KITTTITAS COUNTY DEPARTMENT OF PUBLIC WORKS

MEMORANDUM

SUBJECT: Wagon Wheel Plat Amendment LP-14-00001

TEANAWAY WAGON WHEEL PLAT AMENDMENT  
 VACATE and RELOCATE PORTIONS OF BOONDOGGLE ROAD AND EAST BOONDOGGLE ROAD  
 Portions of Blocks 1, 2, 5; In Parts of the SE4NW4; SW4NE4; NE4SW4; NW4SE4; S26, T21N R15E WM  
 Book 6 of Plats, Pages 30 - 43; Records of Kittitas County, November 1973

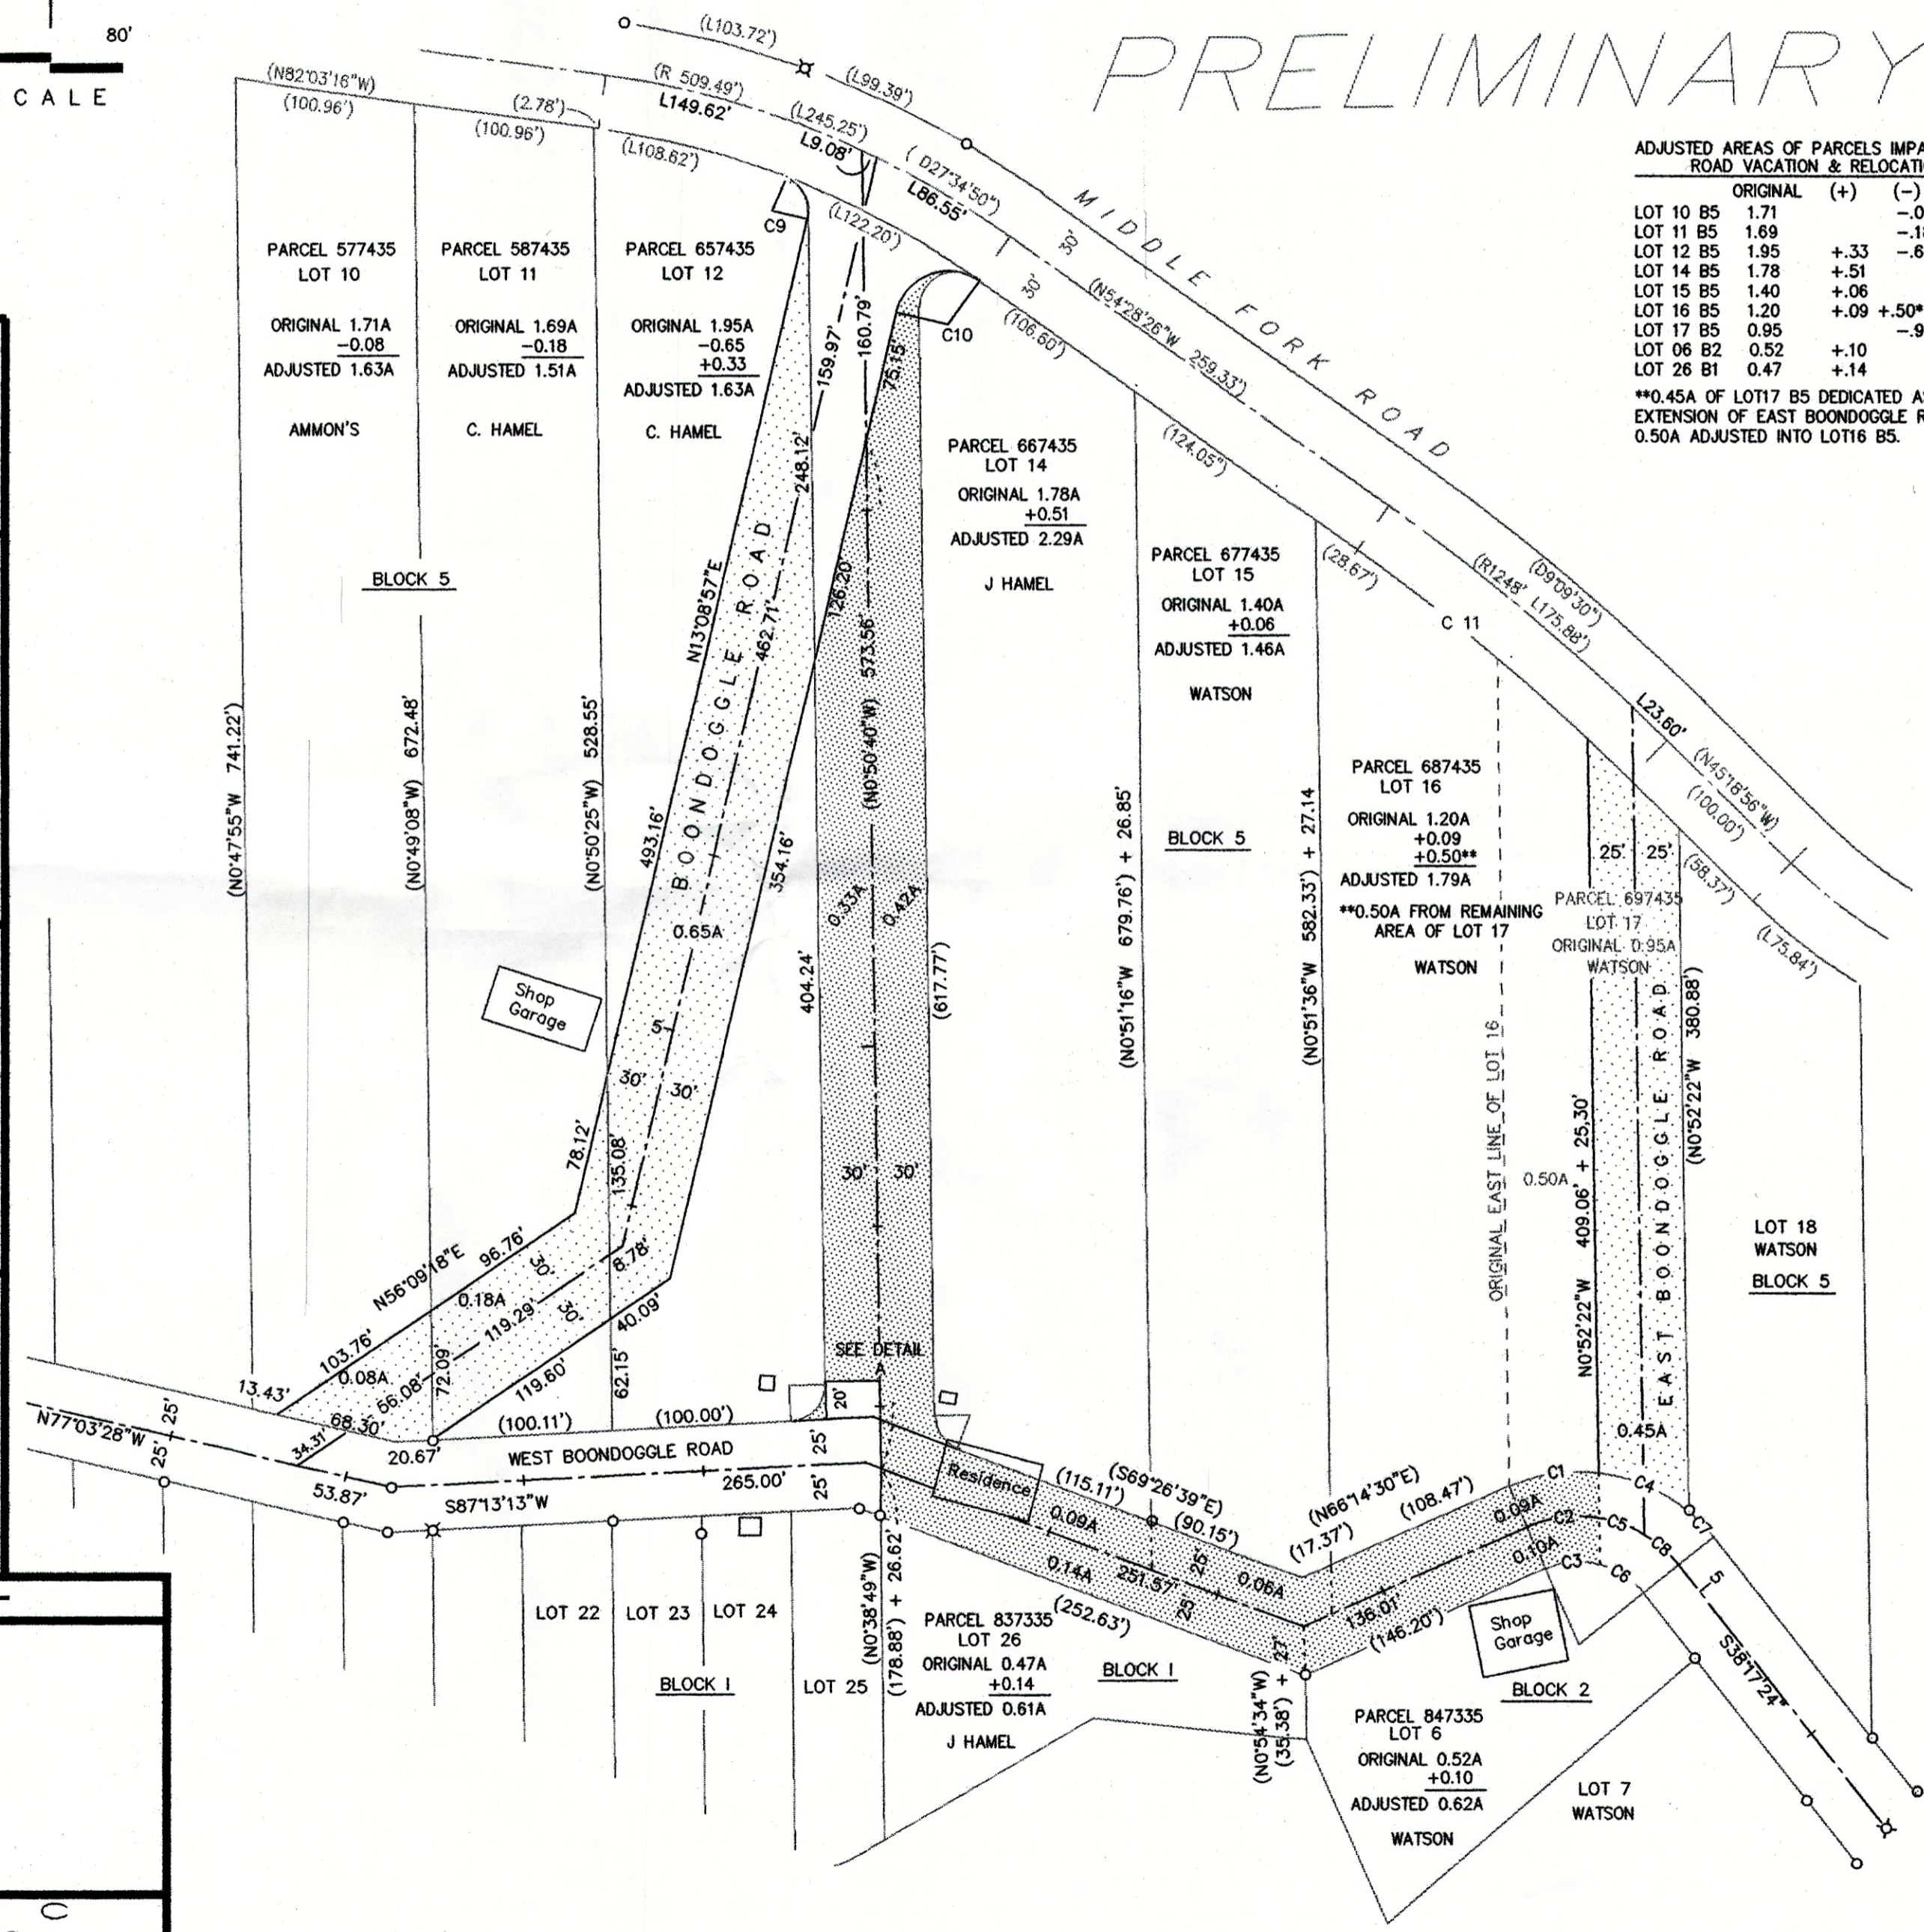
Kittitas County Public Works supports the proposal to vacate and amend roads within the Teanaway Wagon Wheel Plat. While the lot sizes may be non-compliant with current zoning regulations, the plat amendment solves issues that have needed resolution for many years, including roads outside of the right of way and houses constructed within the right of way. See Attachment 1 for a map showing the road system.

This development application is not creating any new parcel or roads. It is only moving the rights of way, changing parcel lines and two lots are being combined, resulting in a decrease in the number of lots than currently exists. The Kittitas County Road Standards require developments which impact the service level, safety or operation efficiency to improve serving roadways in accordance with the Standards, and requires land developed or parcel creations that contain internal roads to construct or improve those roadways to the Standards. Because there will be no change in the ability to develop the existing parcels, and no new lots are being developed, Public Works will not require the roads to be constructed to current standards.

Figure 2: Boondoggle Road Dedication and Vacation. Dedication shown in green, vacation shown in Orange. Boondoggle Road is currently within the green area.

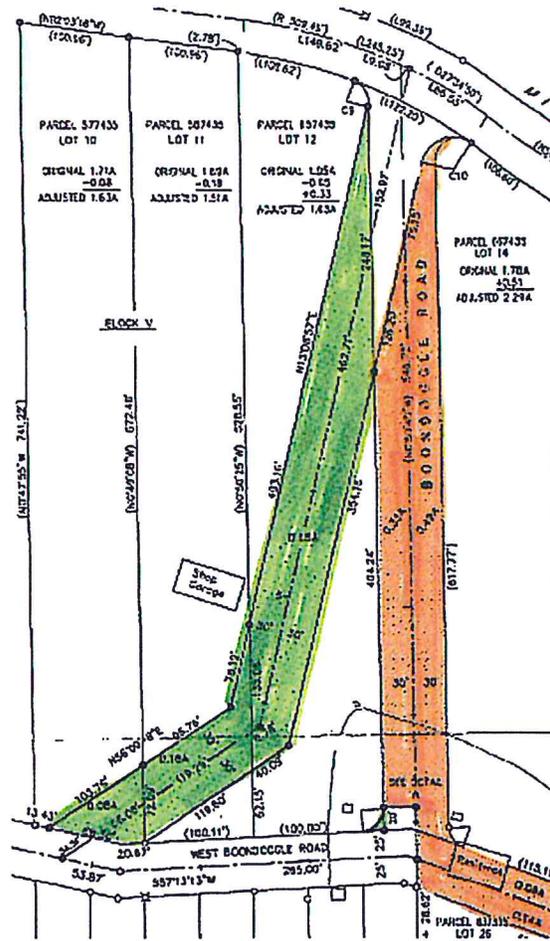
The plat contains many privately maintained roads within the public right of way. One of the roads in question, Boondoggle Road, has always been a privately maintained roadway. It is unknown whether the road was constructed before or after the plat. Aerial photographs from 1964 do not show the road, and the next set of photos to show the area is 1993. Boondoggle Road does not lie within the dedicated public right of way, and all users must travel over private property. The road serves around 30 properties.

Two solutions exist to fix the Boondoggle Road location problem: moving the road or moving the right of way. Moving the right of way is the preferred alternative to Public Works. After the right of way is moved, all properties will have legal access.

Figure 3 (left): Eastern Road dedication, shown in green.

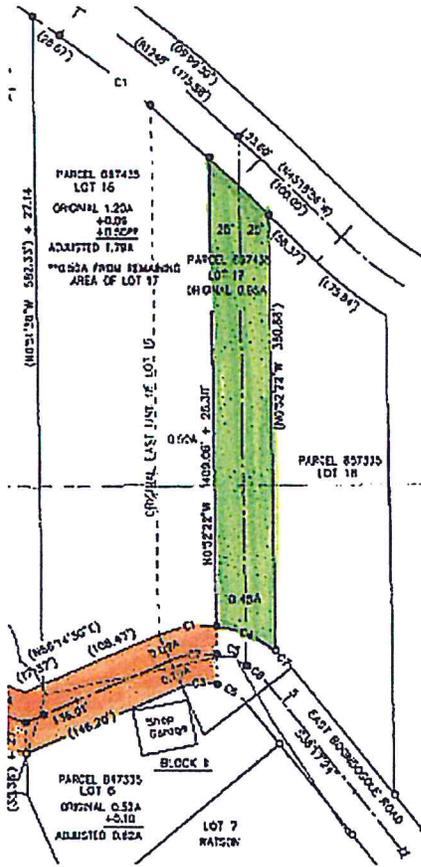
This plat amendment also includes the dedication of a 50' right of way which is currently unnamed through lot 18 (hereafter referred to as the "Eastern Road"). All rights of way within the plat, except for the north-south portion of Boondoggle Road, are 50' in width.

The Eastern Road serves about seven parcels, but the north-south portion crosses over private property. This plat amendment and dedication of public right of way will create legal access for those properties.

Figure 4 (below): Lots involved in the road vacation. Vacated right of way shown in orange. Hammerhead dedication shown in green.

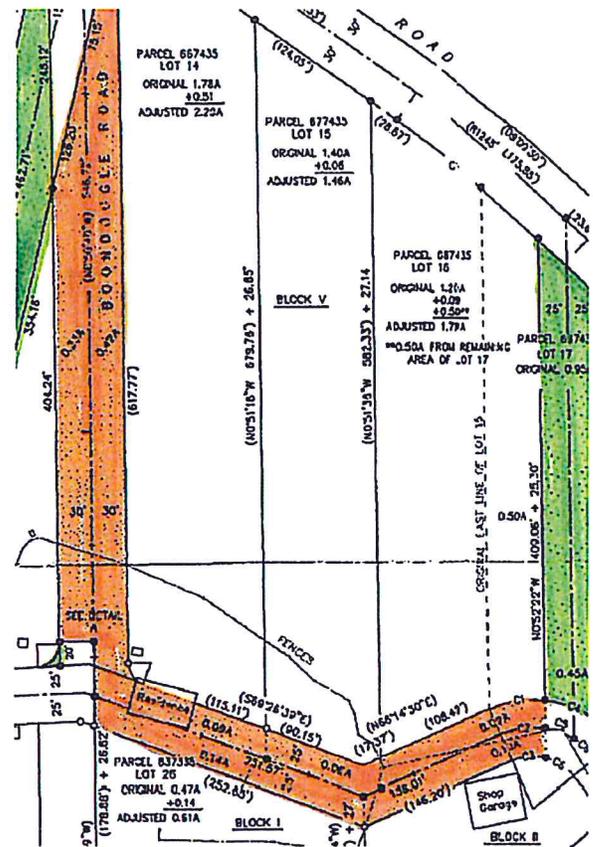
With the configuration of Boondoggle Road and the Eastern Road, the right of way within Lots 6, 12, 14, 15, 16 and 26 is no longer necessary. The plat amendment includes vacation of the right of way adjacent to those lots. In addition, the house on parcel 837335 is within the right of way and the vacation will put the house within the boundaries of the property instead. See Attachment 4.

The spur road shown as West Boondoggle Road on the submitted drawings retains and dedicates right of way for a hammerhead turnaround.

Figure 5: Temporary access easements shown in yellow to serve Lot 26 and Lot 15.

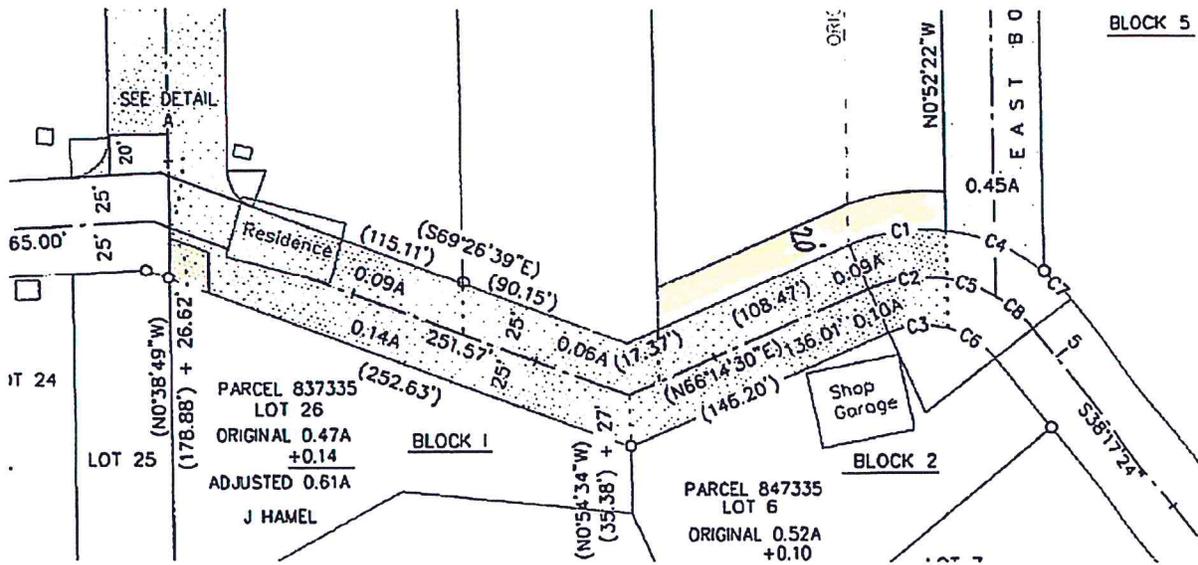
A boundary line adjustment is proposed after the plat amendment is completed that will provide each lot with direct access to the dedicated public right of way. Prior to the boundary line adjustment, lots 26 and 15 do not have direct access to the dedicated public right of way. Because all lots must have legal access, temporary easements will be shown on the plat with a note stating they will be relinquished at such time that each lot has direct access to the dedicated public right of way or a legally recorded easement in a different location. The intention is to allow the temporary easements to be relinquished without requiring another plat amendment. See Attachment 5.
